Our Ref: F2004/07906

Your Ref: SSD 6339

**Re: St Catherine's School Master Plan**

TRAFFIC MANAGEMENT AND PARKING

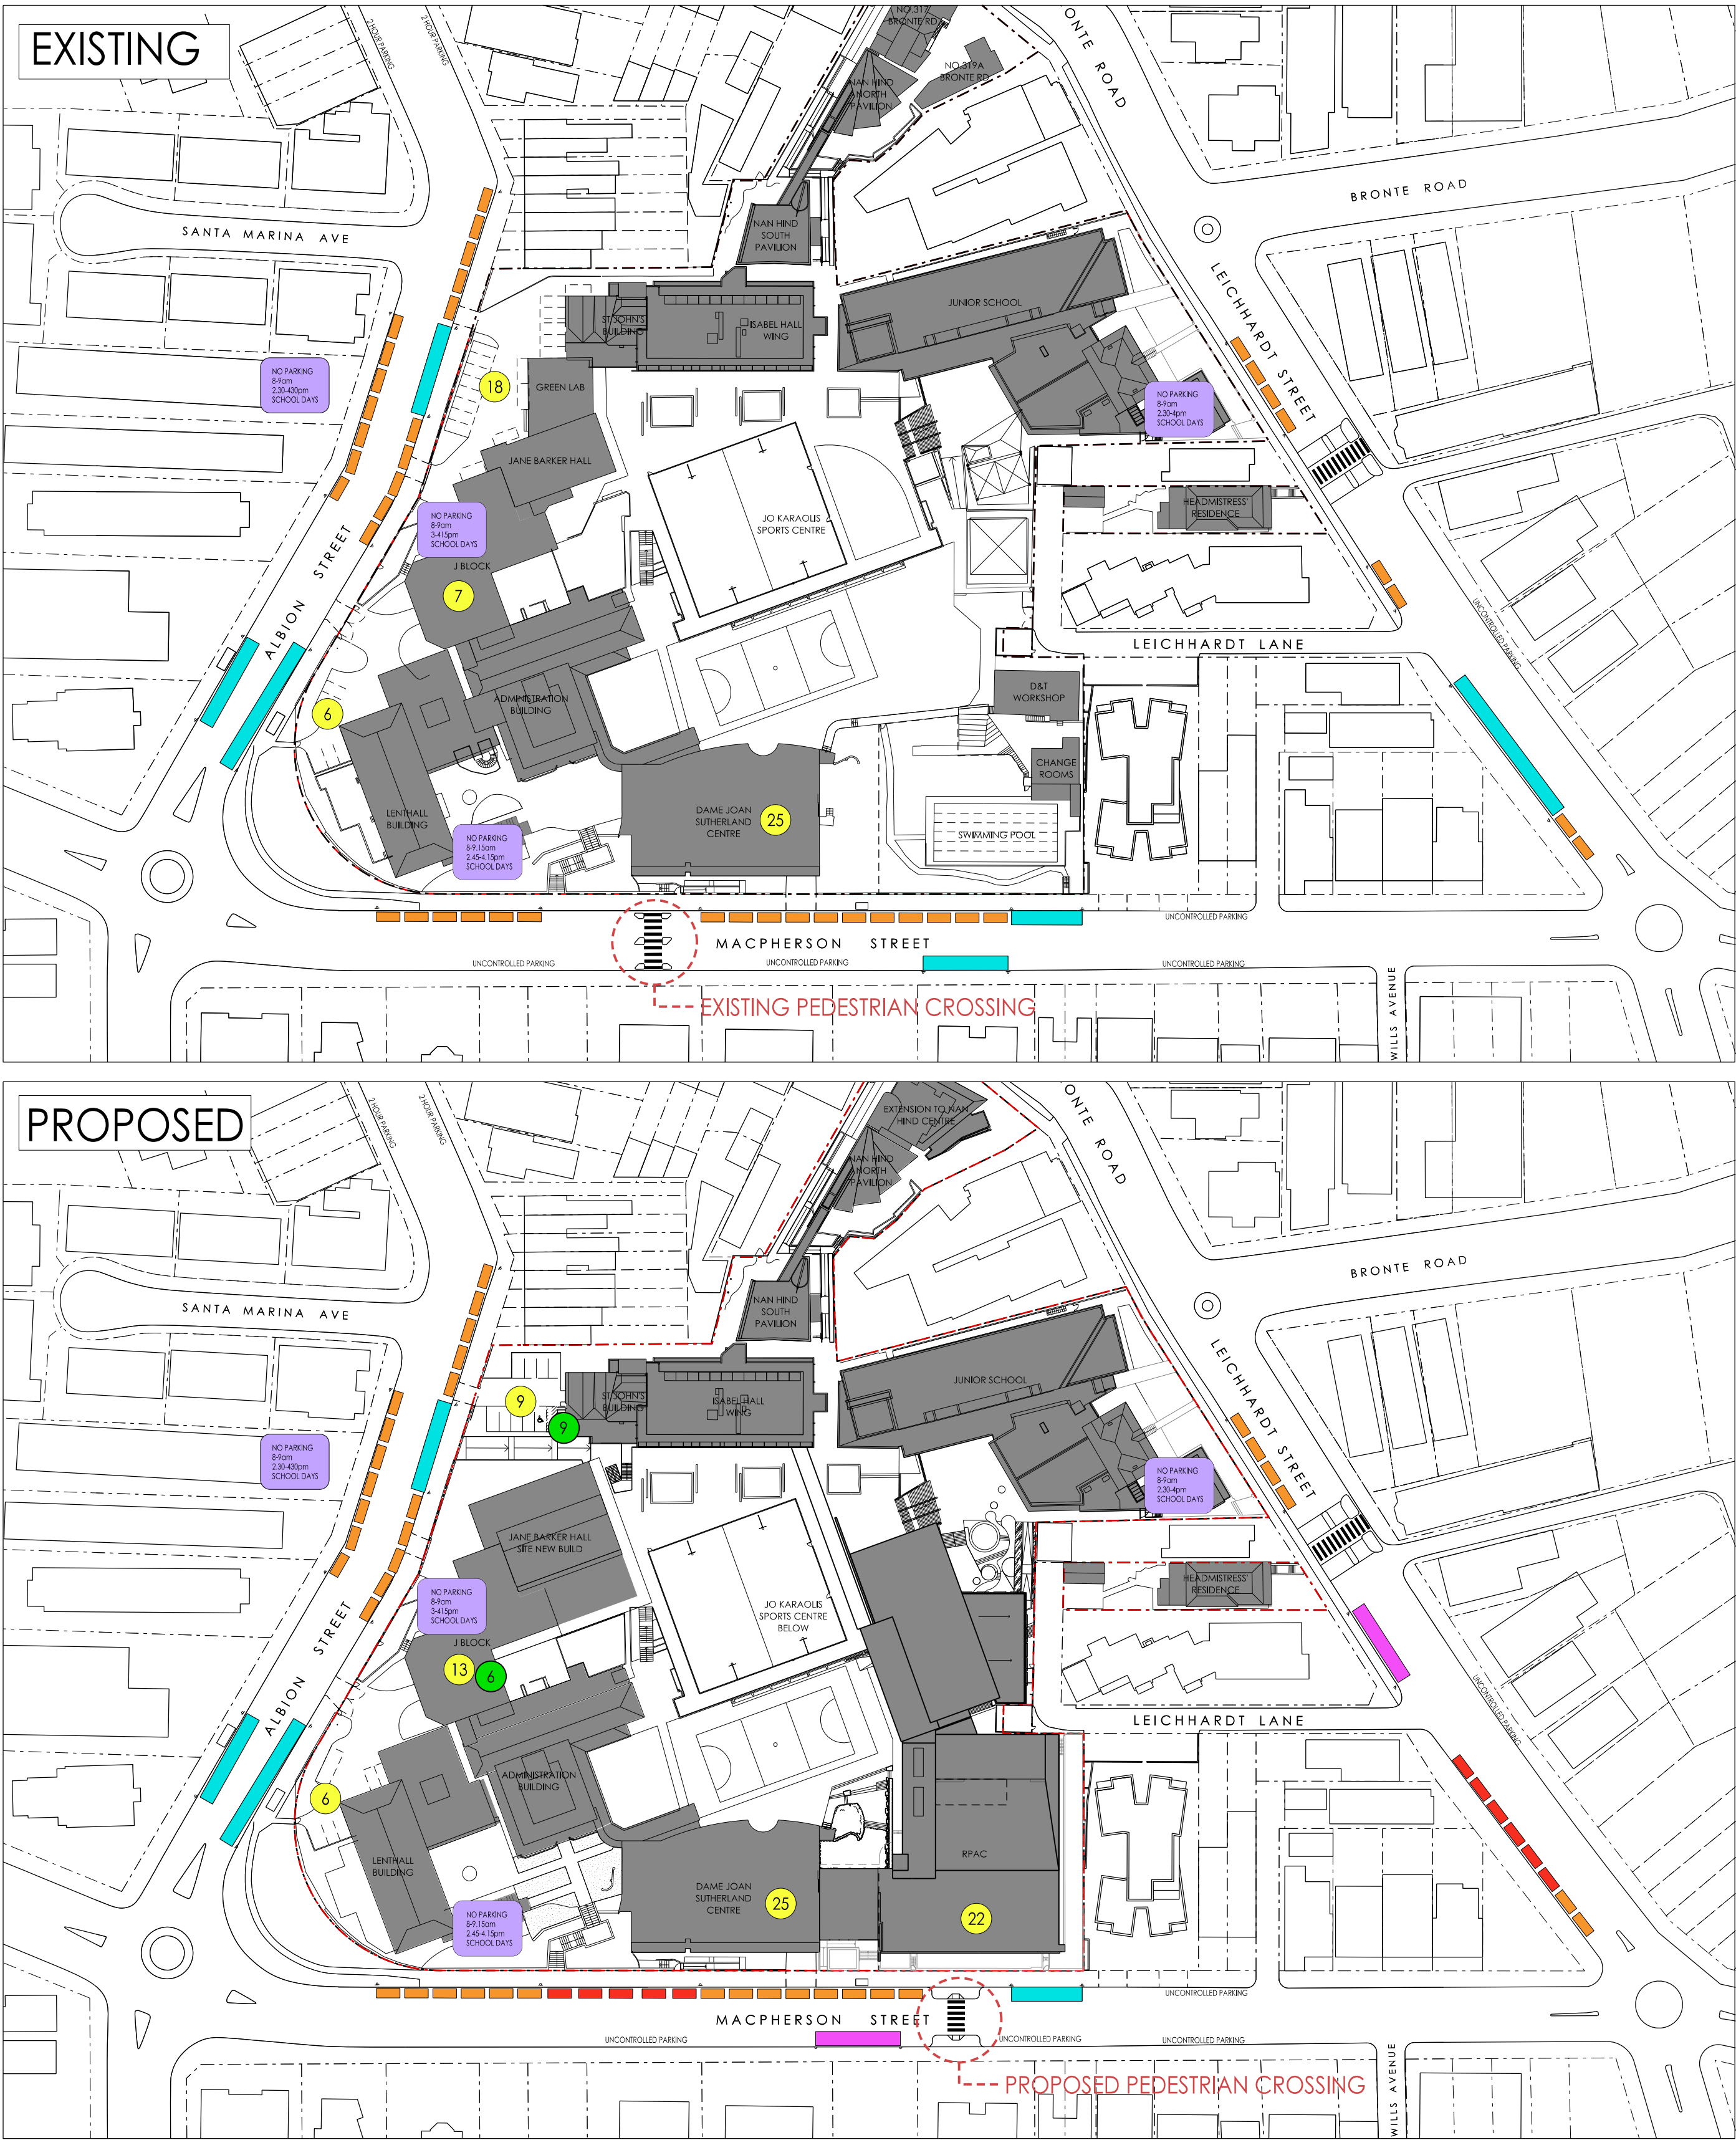
- (a) the Master Plan be amended to provide a substantial amount of additional on-site parking, for example a minimum of 200 car spaces - currently only 19 extra car spaces are proposed in addition to the existing 56 car spaces. This is essential due to, but not limited by, the:

- existing over-subscribed on-street parking available in the area,
  - proposed increase in capacity of the school, including students, teachers, staff, and visitors, and

- proposed intensification of school functions associated with the new buildings, including the 500-seat theatre and larger aquatic centre. The development of the Research, Performing Arts & Aquatic Centre (RPAC) should be dependent on providing the additional parking, that is, the parking should be physically provided with the first stage of development;

LANDSCAPE AREA AND BUILDING FOOTPRINT

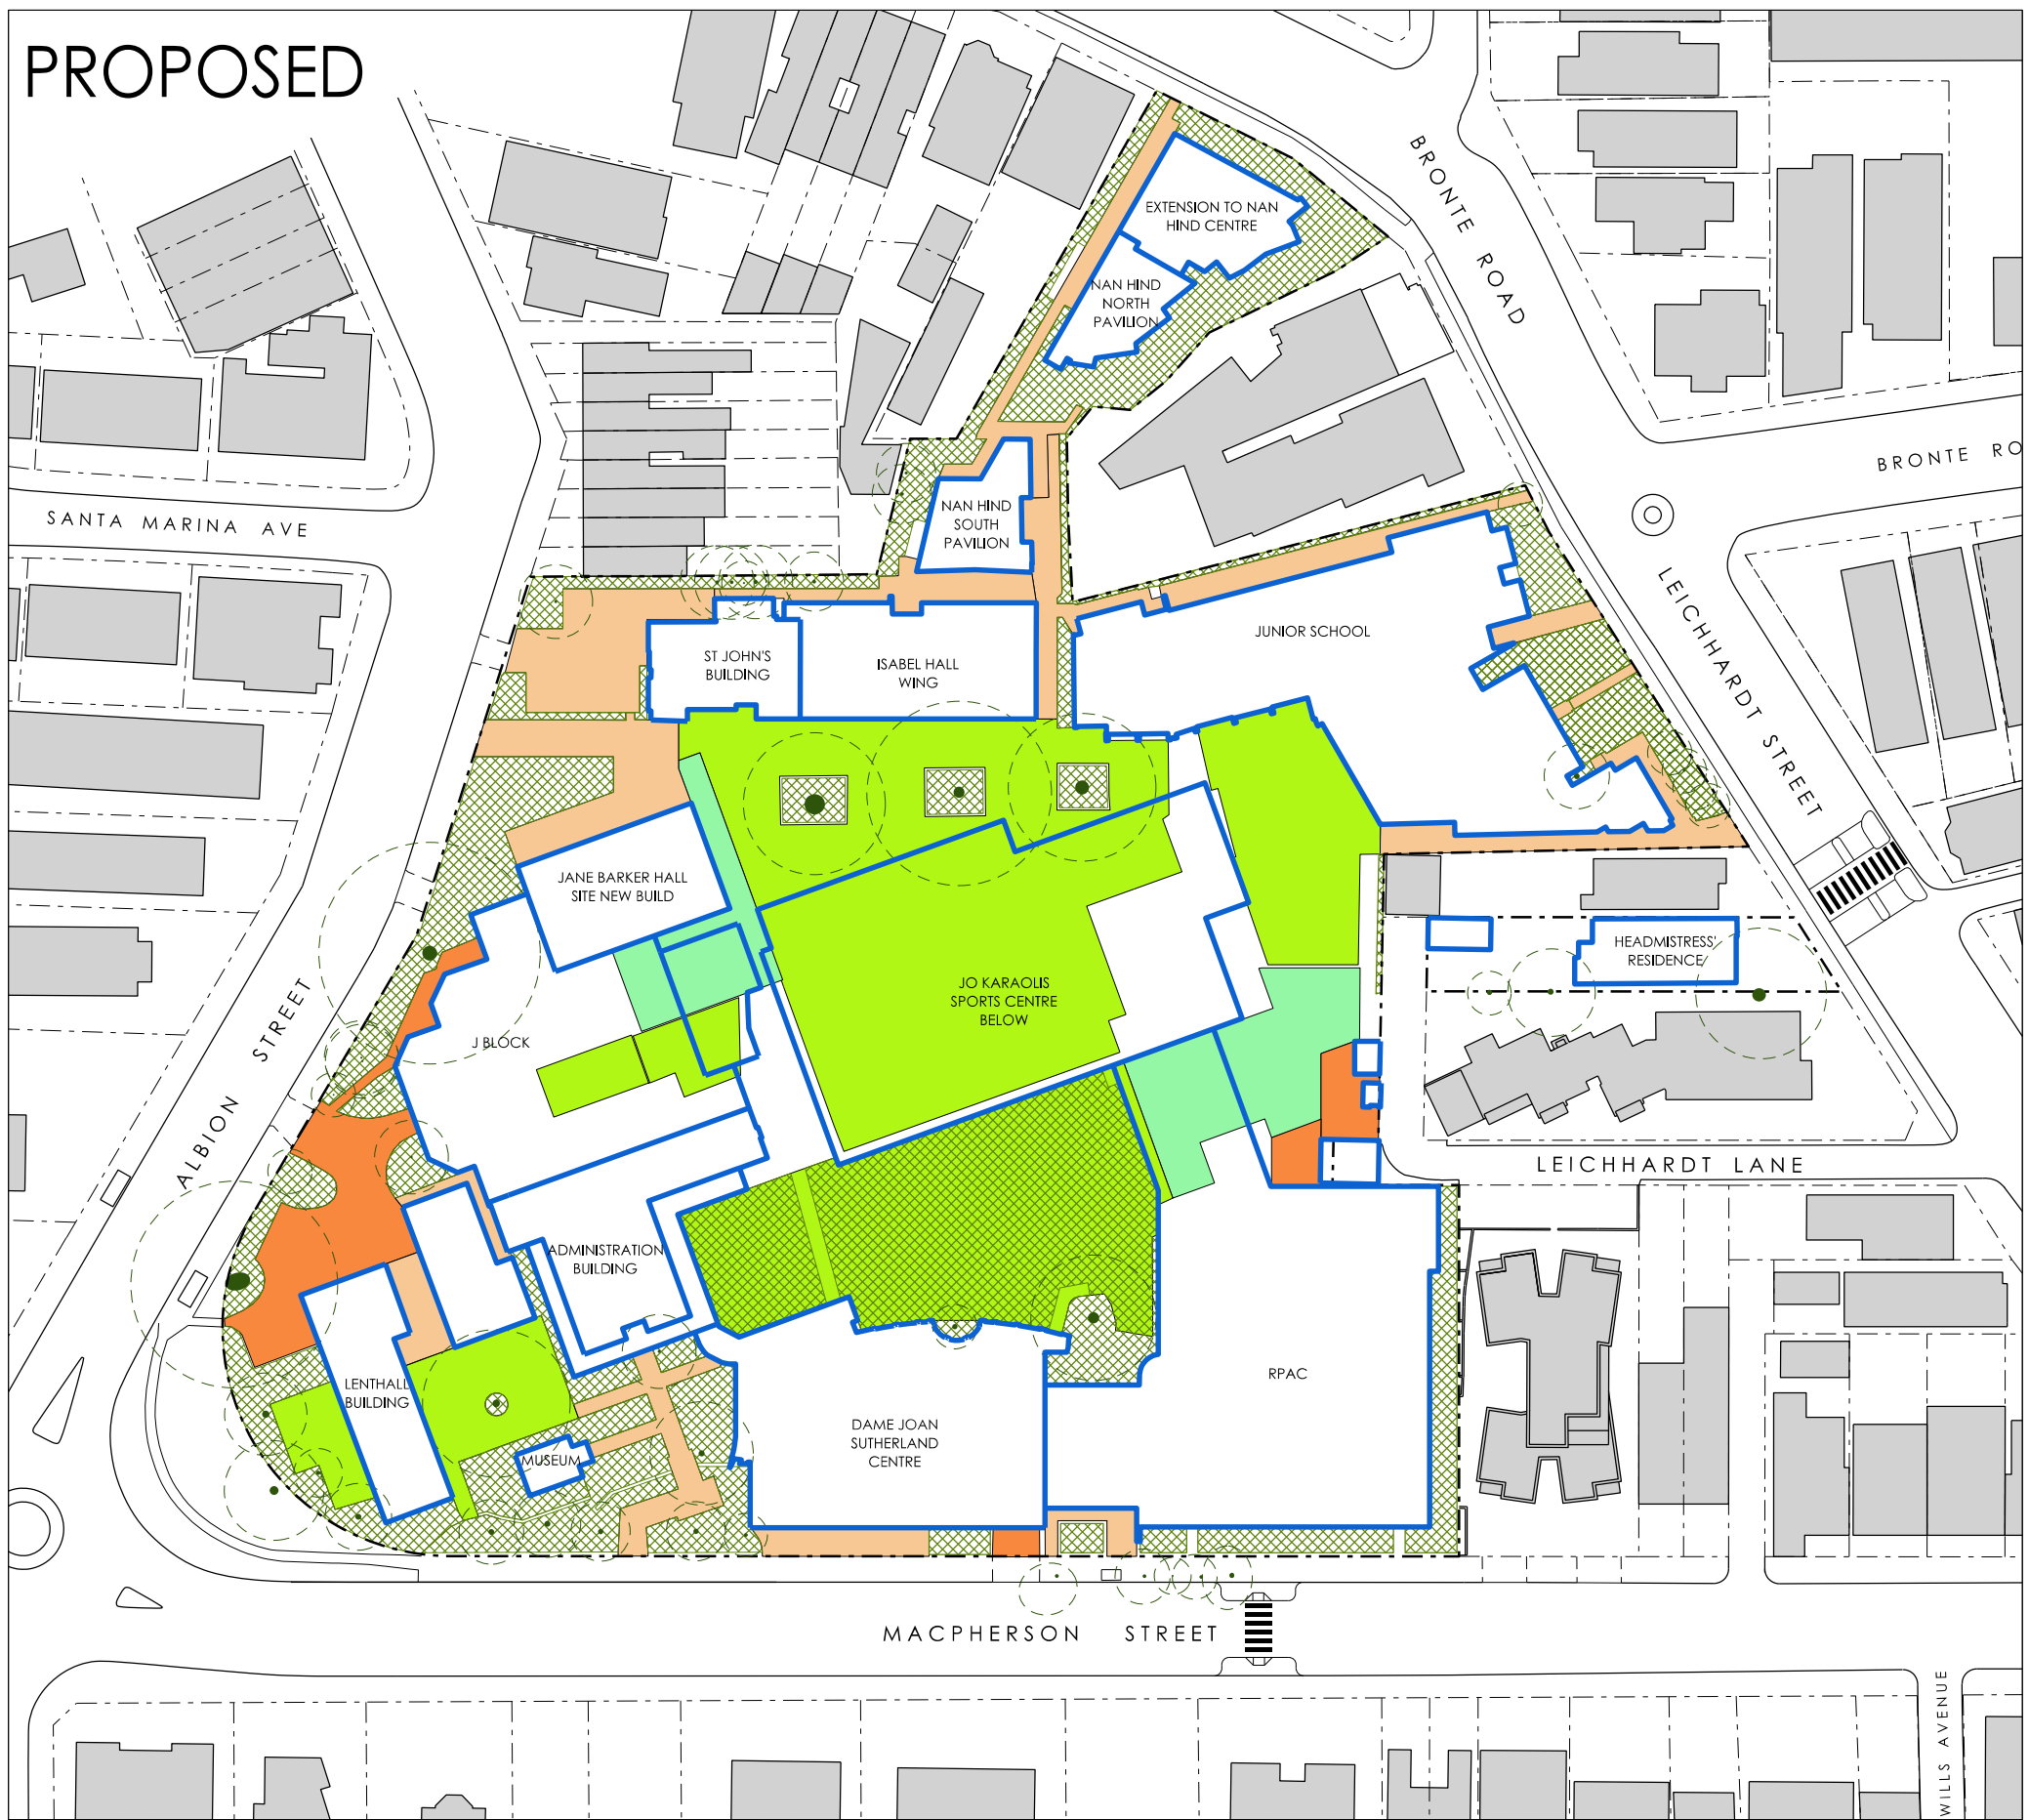
(c) the site coverage of the proposal should be reduced so as to minimise the loss of green space and minimise overdevelopment of the land; and
